Hello,
Thankyou very much for the consultations. The **Arun Conservation Area Advisory Panel** wish the following comments to be taken into consideration in the determination of the applications:

FG/35/26/HH and FG/36/26/L - Home Farm House, 63 Ferringham Lane, Ferring

Client:	JANE CHEAL
Project:	Home Farm House 63 Feelingham Lane, Ferring
Drawing Title:	Window Details
Scale:	No Scale
Date:	18/3/2026

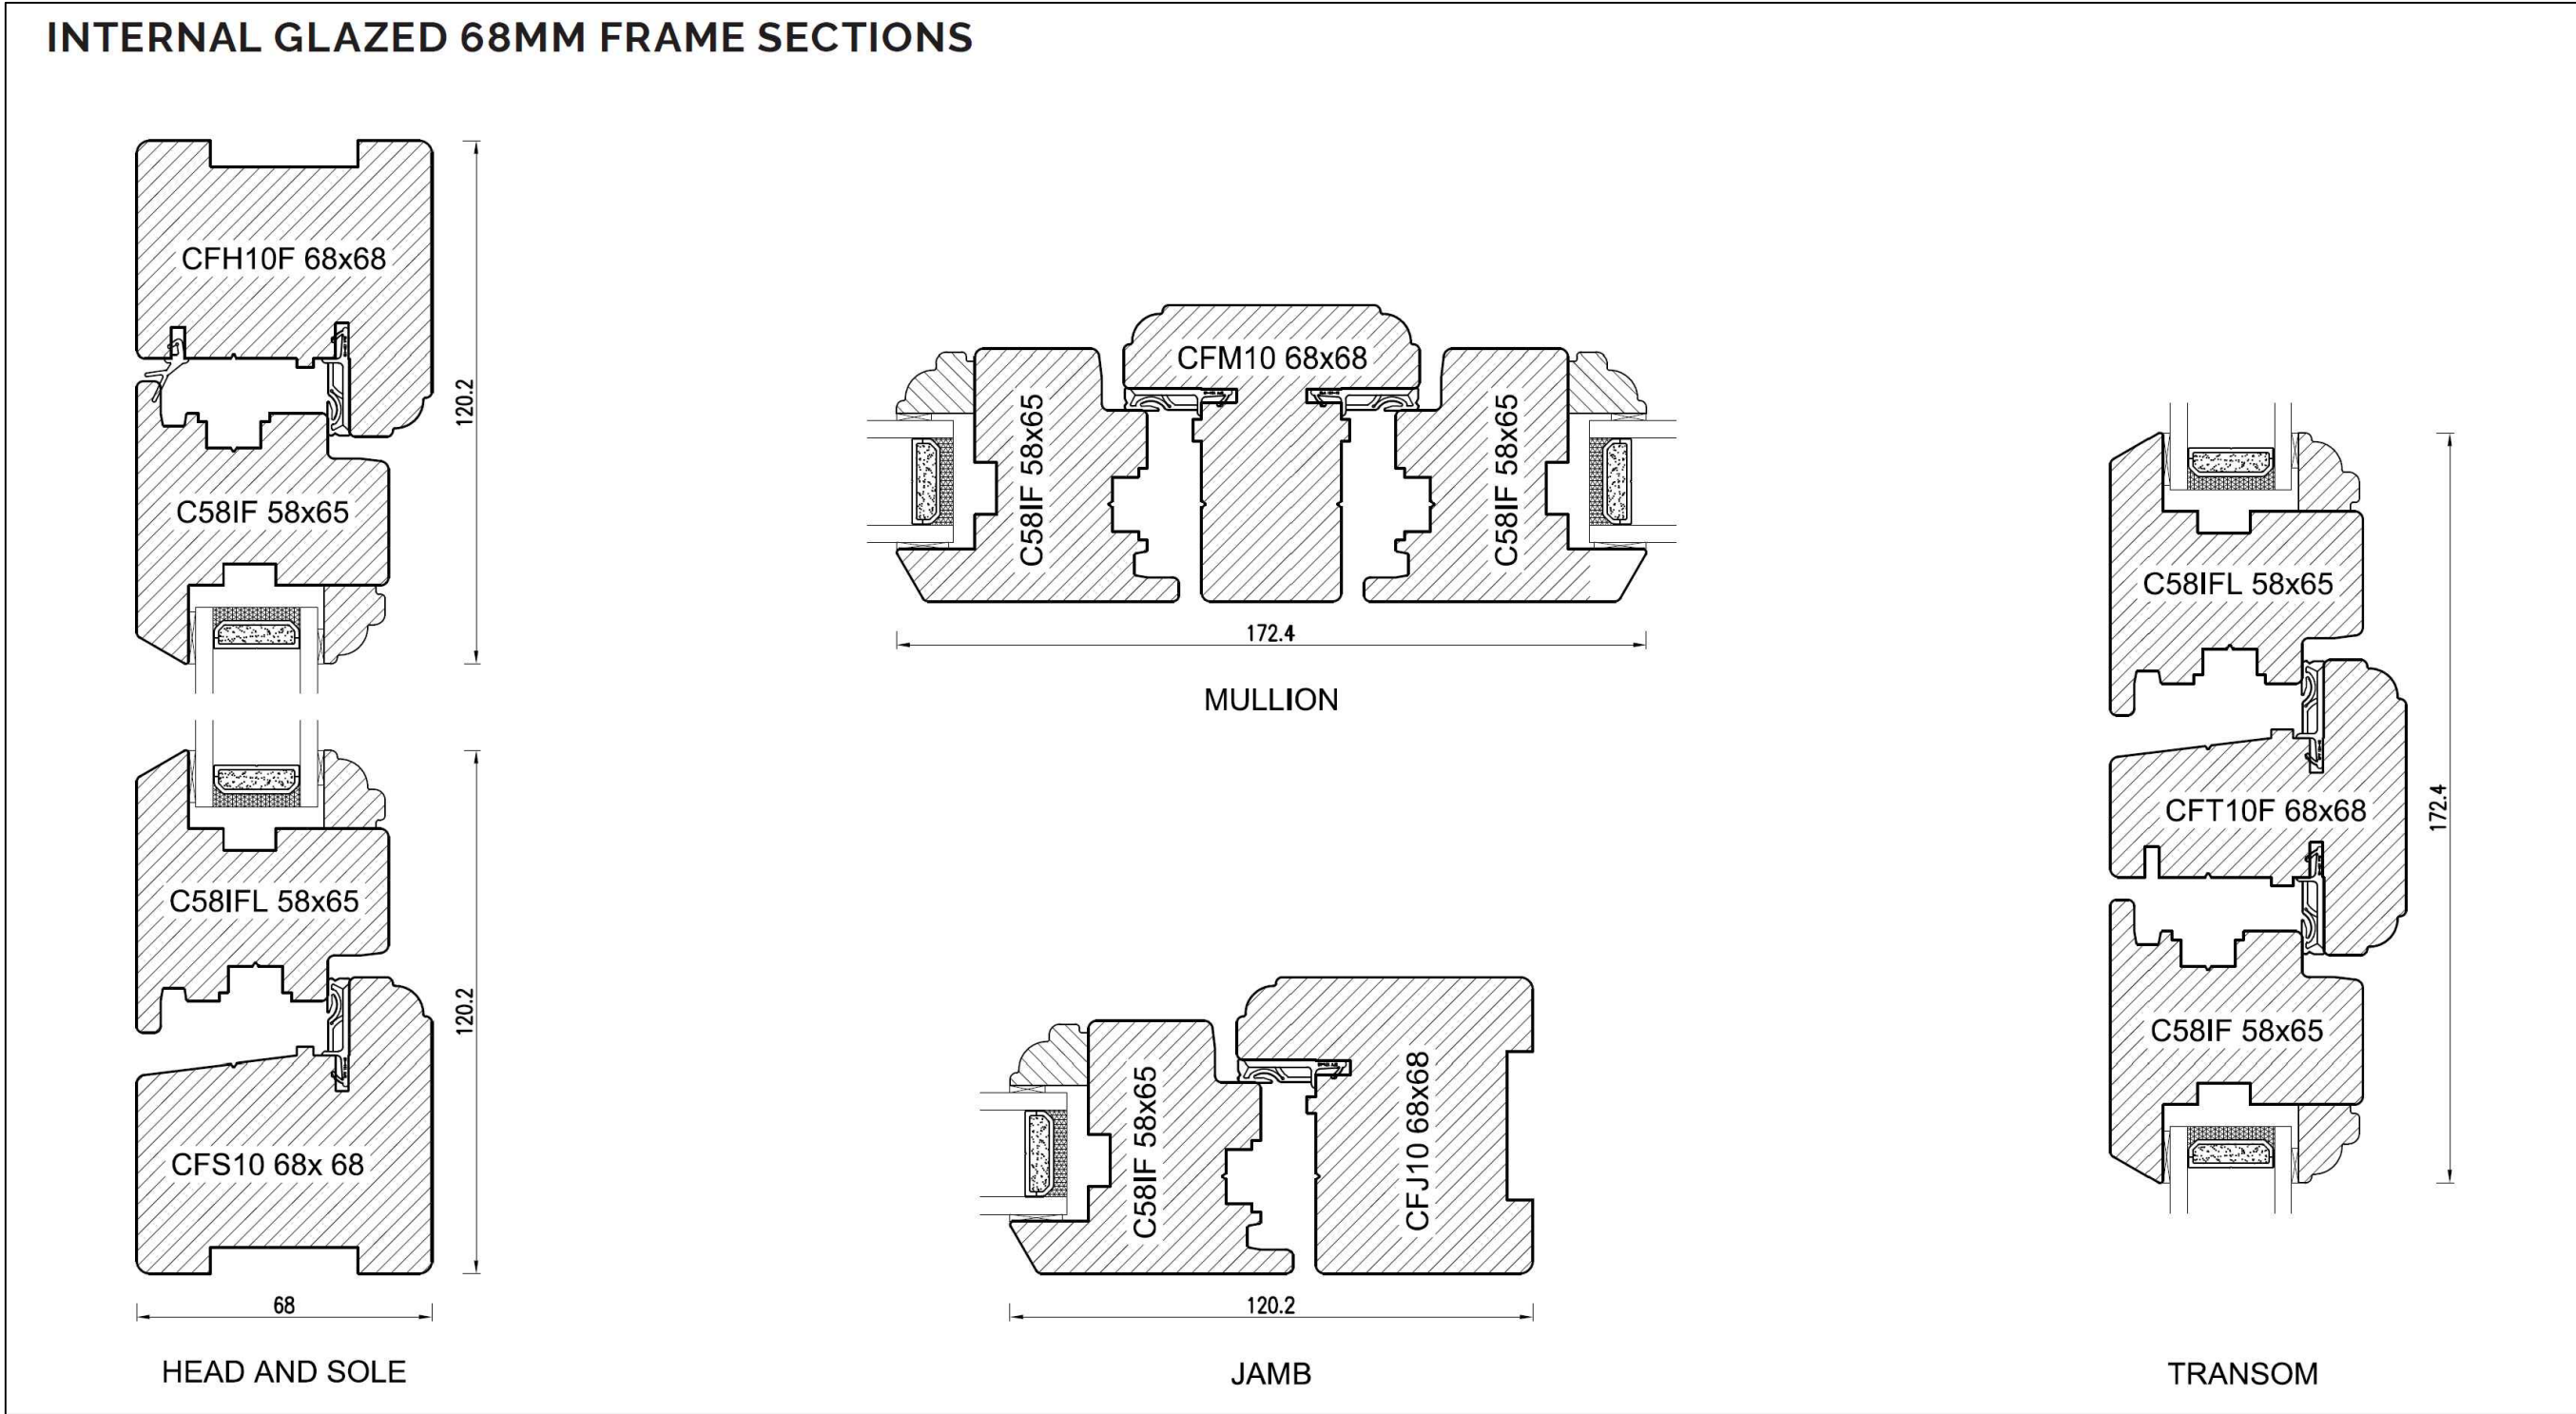
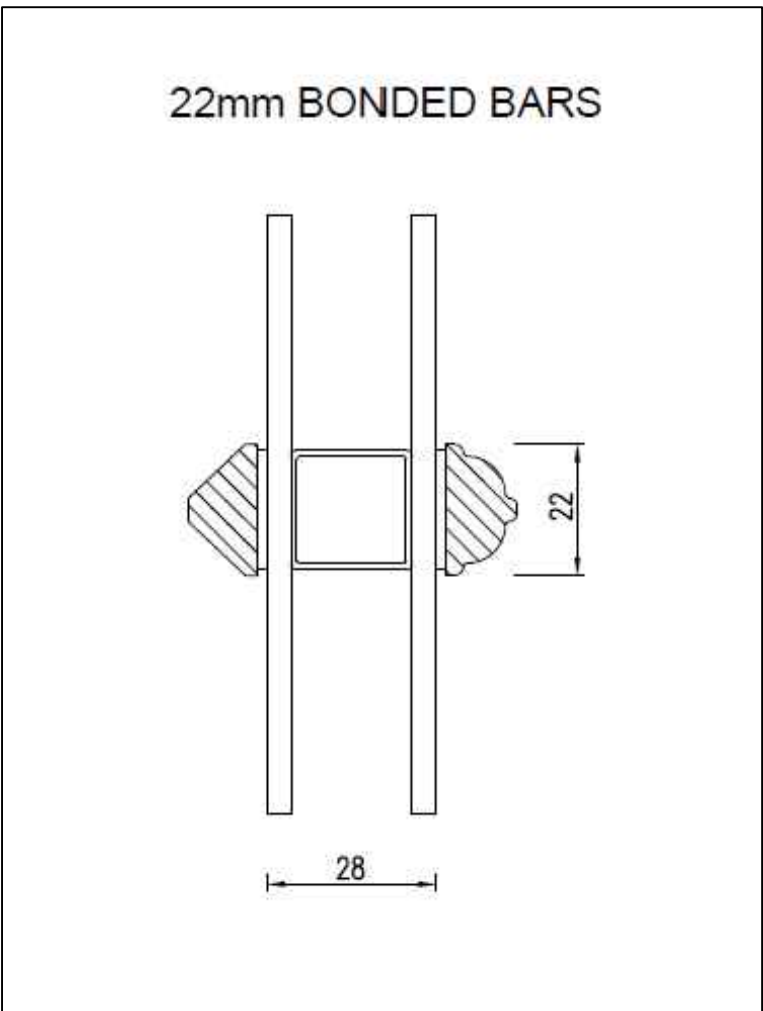
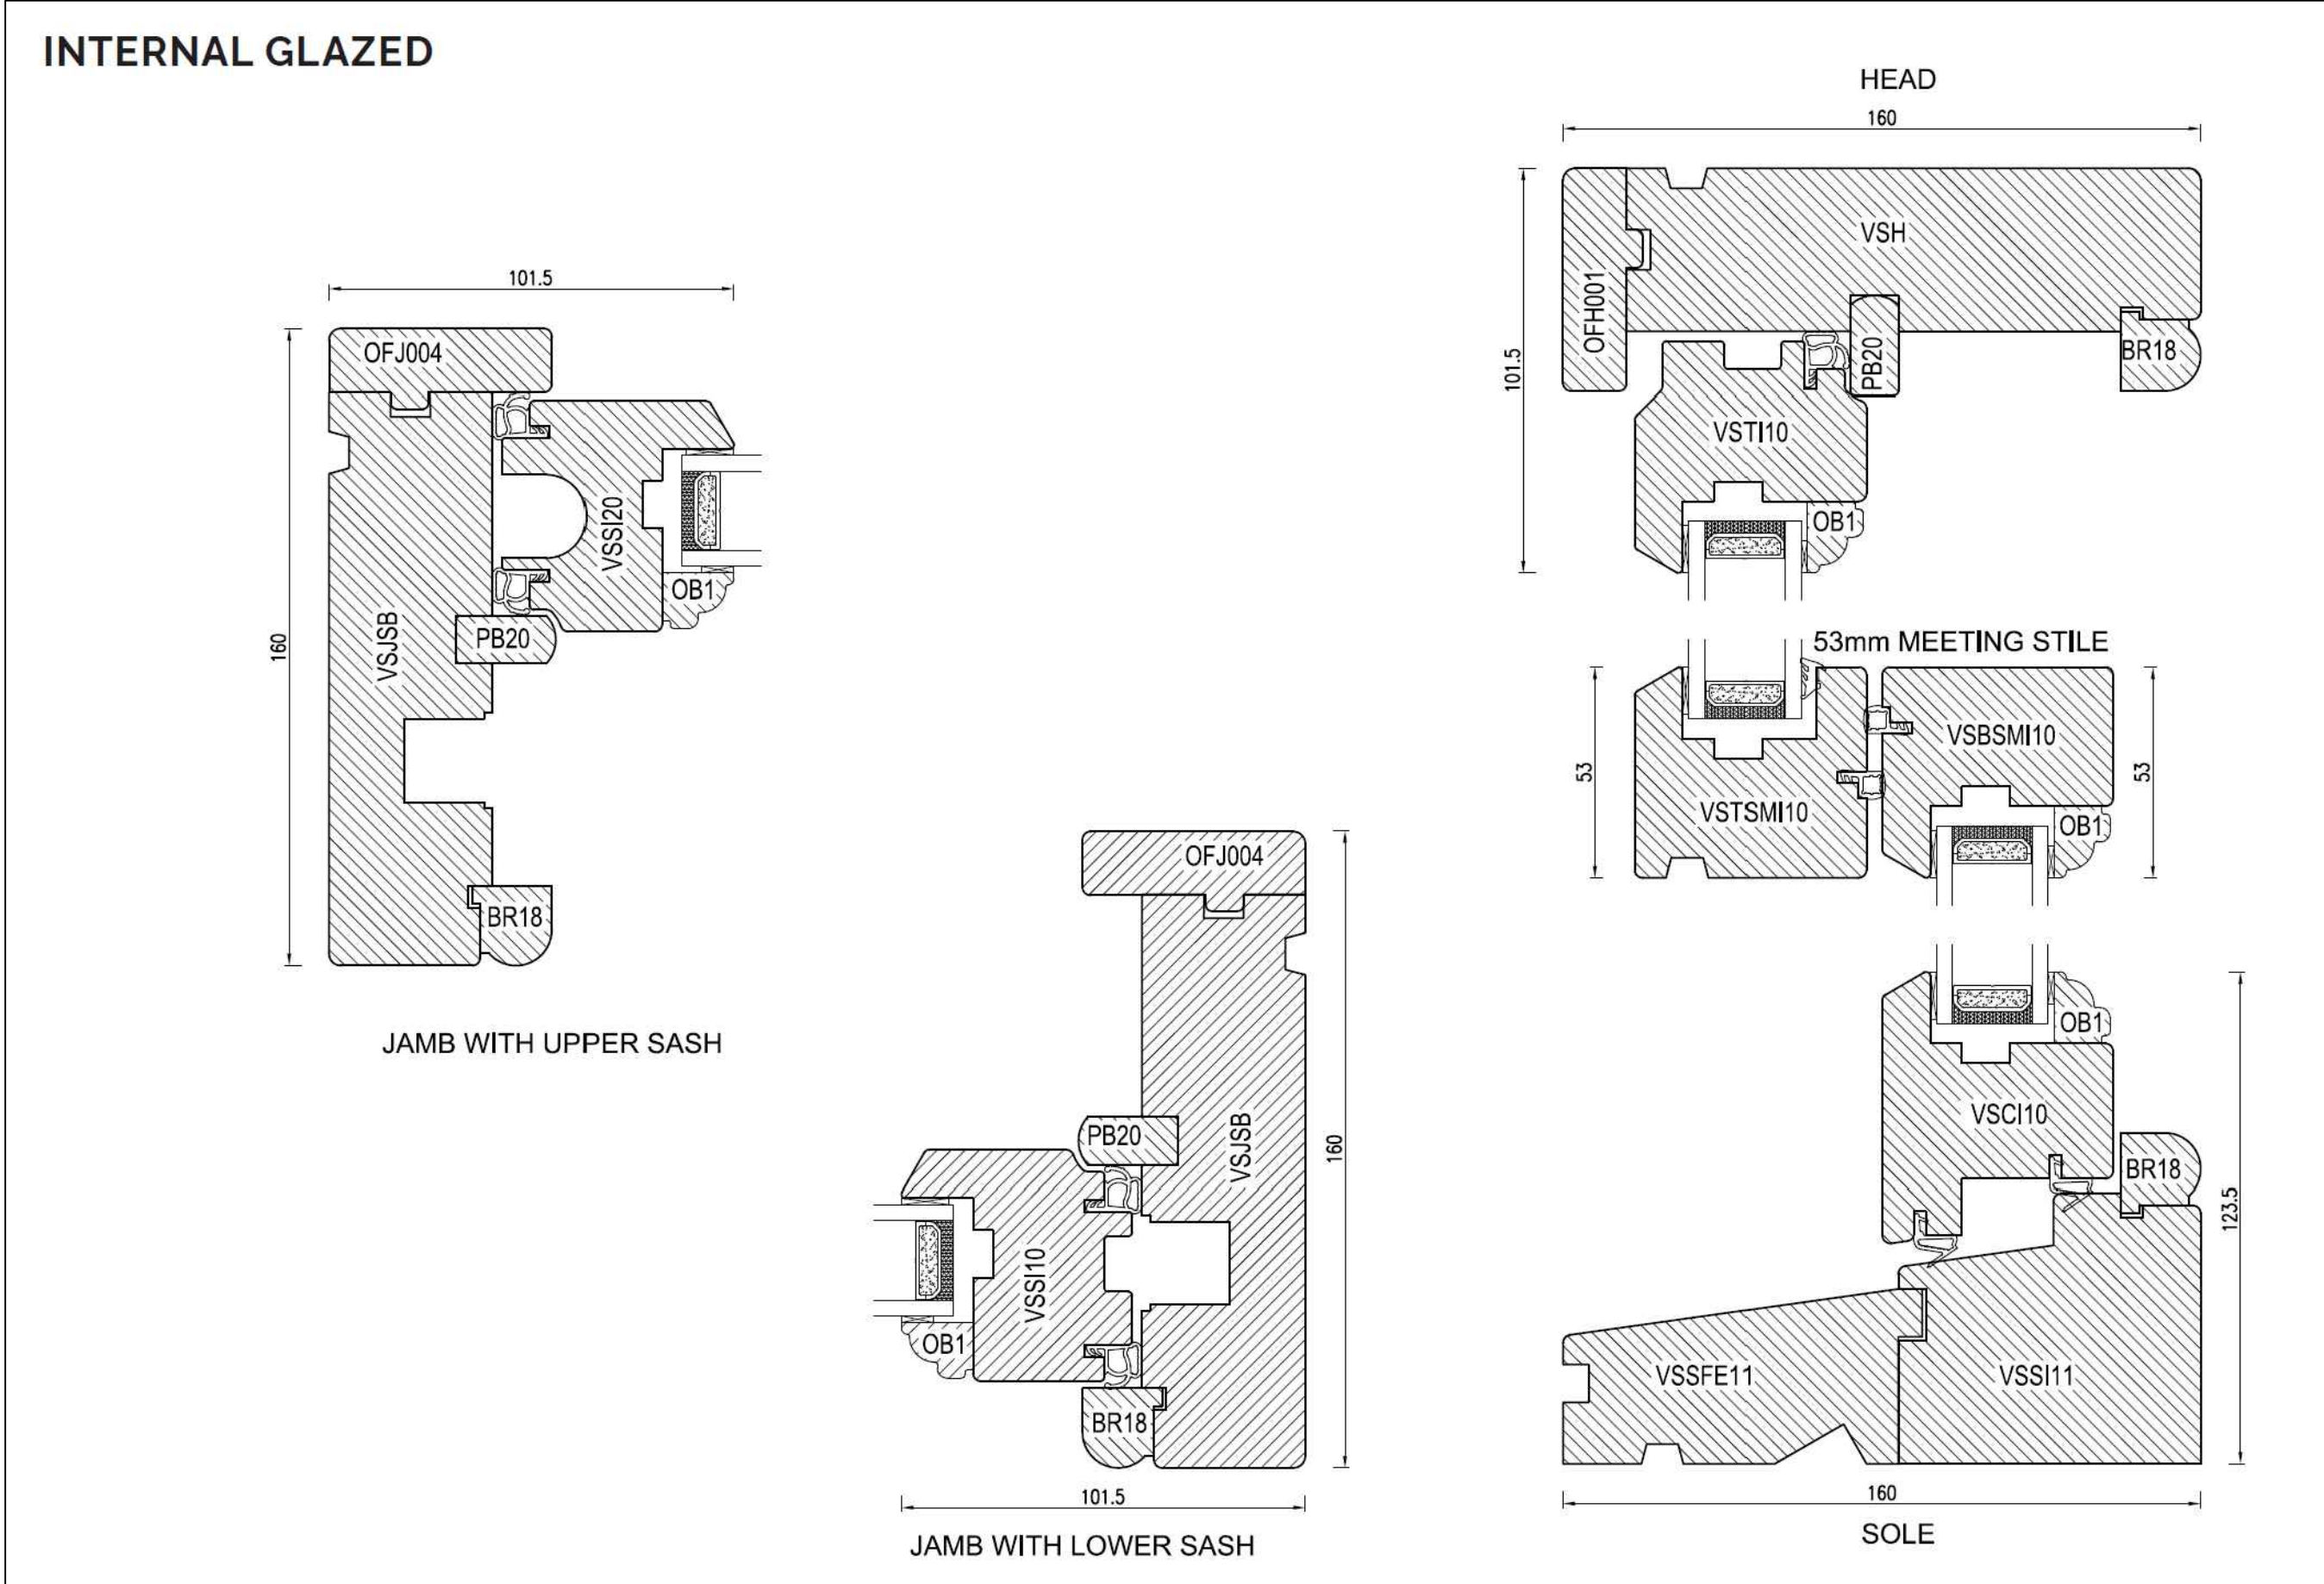
The age, design and architectural merit of the building indicate that its windows are an essential part of its heritage significance.

The advice of Historic England does not appear to have been followed in this instance. There is no comprehensive condition report on the existing windows to indicate whether or not they can be reasonably repaired. The double glazing units are too thick and the use of false glazing bars is simply inappropriate in an historic building.

Historic England provide ample advice on how to improve the thermal efficiency of historic windows, useful adaptations such as secondary glazing, and if they need to be replaced the best methods of doing so.
